Our Ref: R/115/19/NMA

**Section 96A of the Town & Country Planning Act 1990 (as amended)
Town and Country Planning (Development Management Procedure) (England) Order 2015 (as amended) - Article 10**

Non-material amendment following the grant of R/238/17/HH to bring front face of garage forward by 470mm to align with the front face of bay window of bungalow & bring forward the front false pitch by 470mm to align with front pitch of bungalow,
33 Amberley Road Rustington BN16 2EF

DRAWING NO. 20190524/02

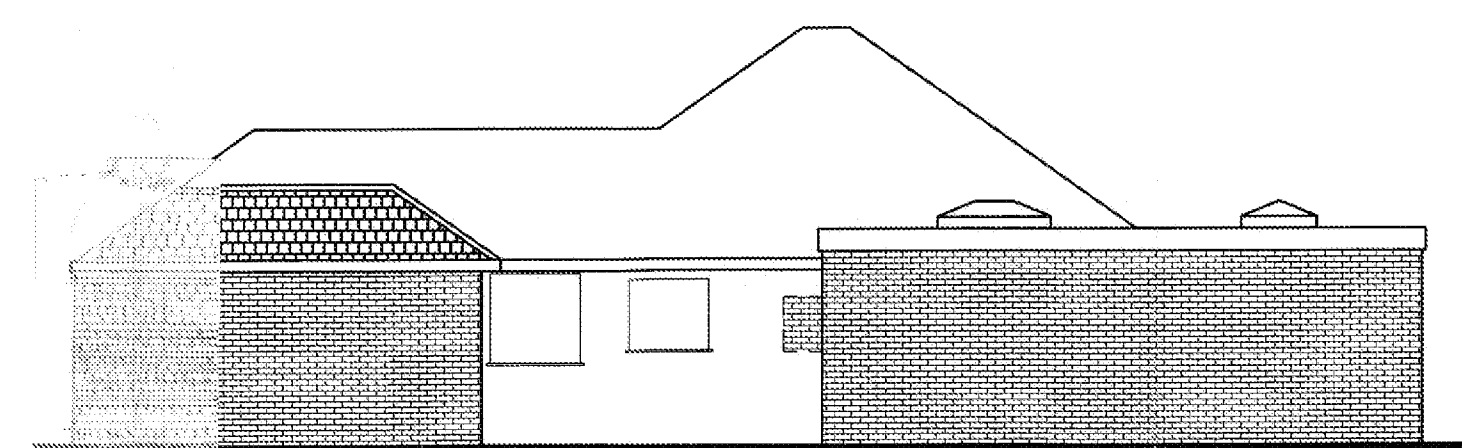
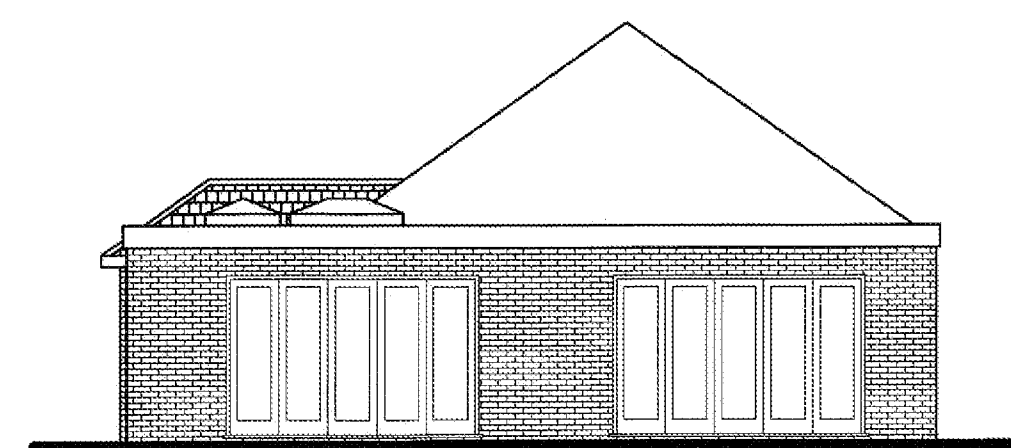
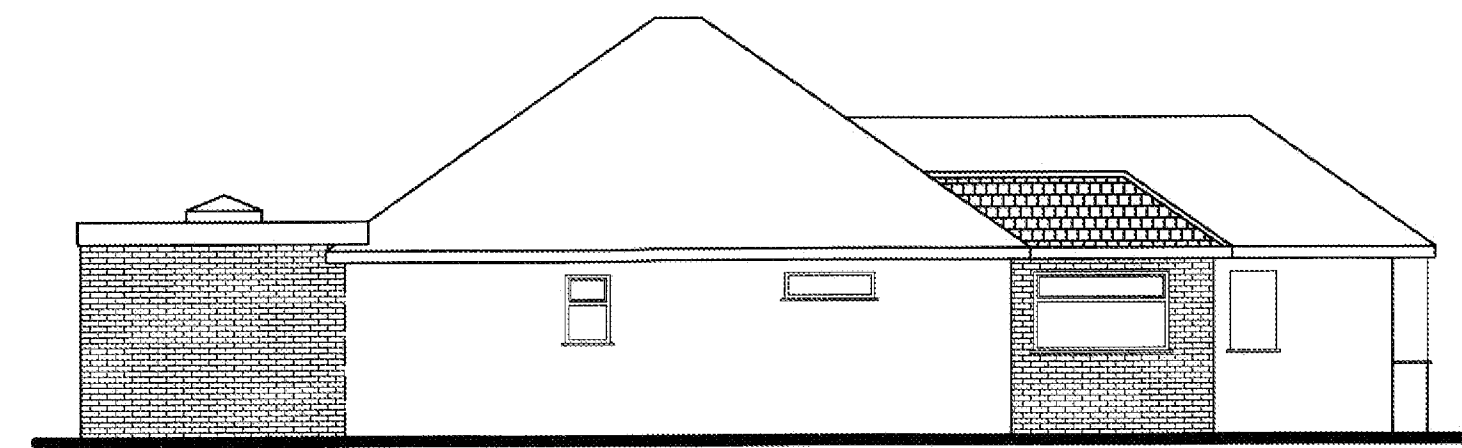
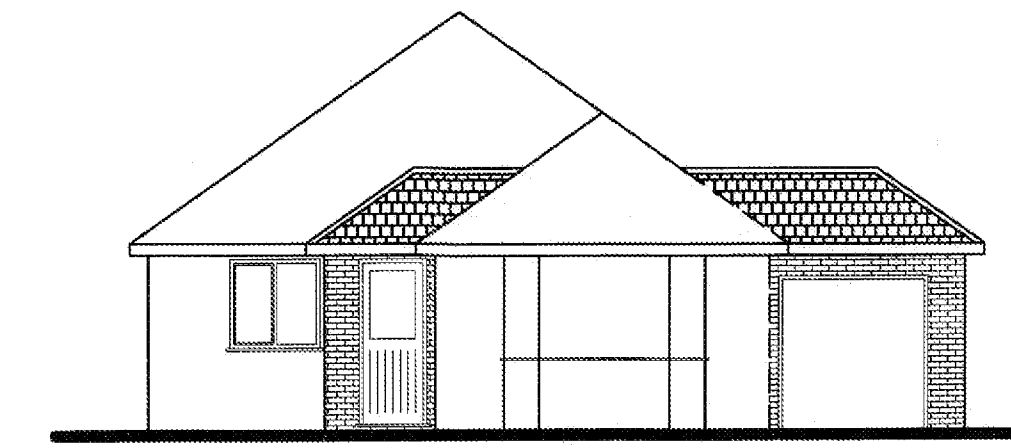
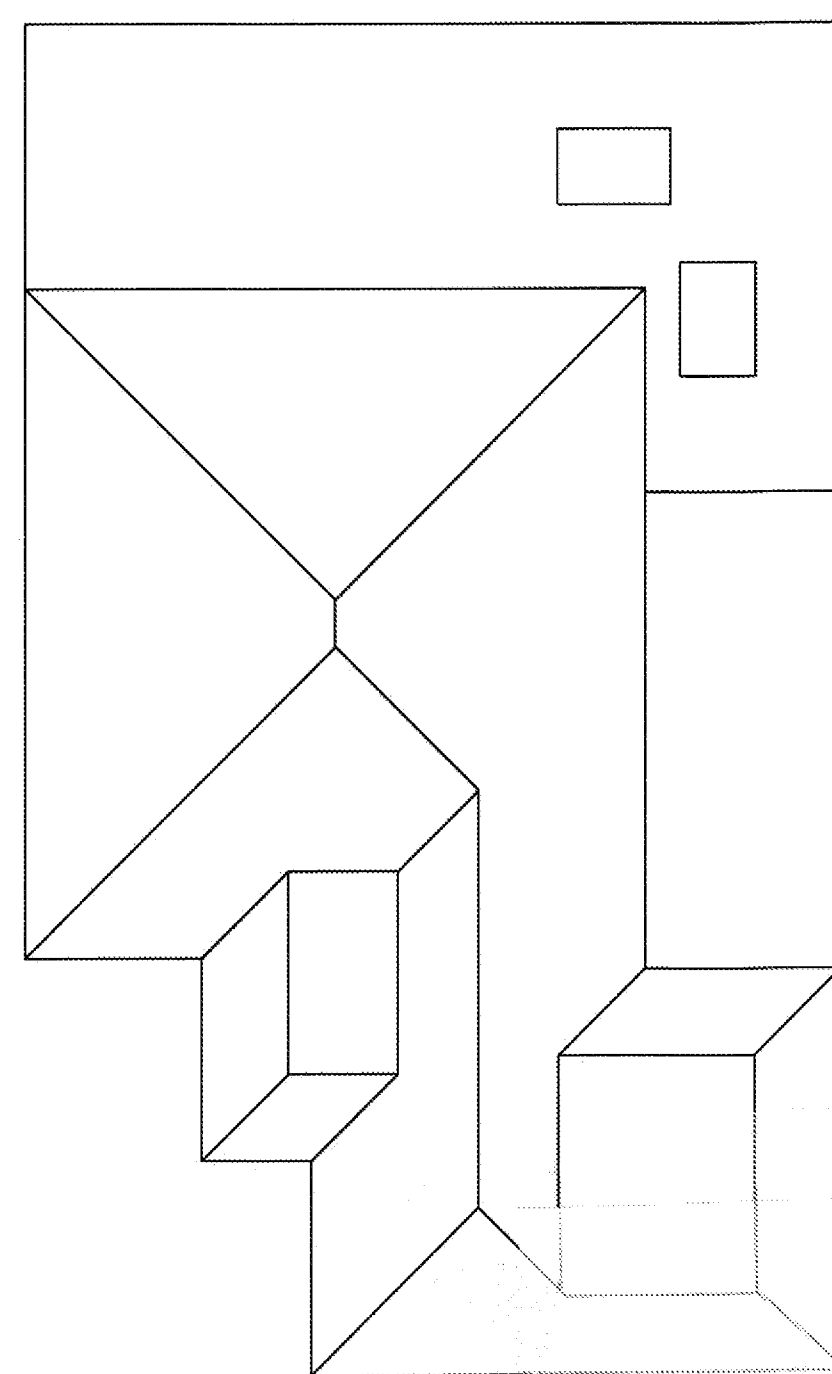
I refer to your recent application for a Non Material Minor Amendment. I note that you propose to bring the front face of garage forward by 470mm to align with the front face of bay window of the bungalow. Additionally, to bring forward the front false pitch by 470mm to align with front pitch of the bungalow.

Please note that plans 'Proposed Rear/side extension and rebuild garage - 16/1259/01 - October 2017 - Drawn by: AWR' and 'Proposed Rear/side extension and rebuild garage - 16/1259/02 - October 2017 - Drawn by: AWR' now are replaced by 'Amendment to garage dimensions - R/238/17/HH - 20190524/01 - May 2019 - Drawn by: PHM' and 'Amendment to garage dimensions - R/238/17/HH - 20190524/02 - May 2019 - Drawn by: PHM' respectively.
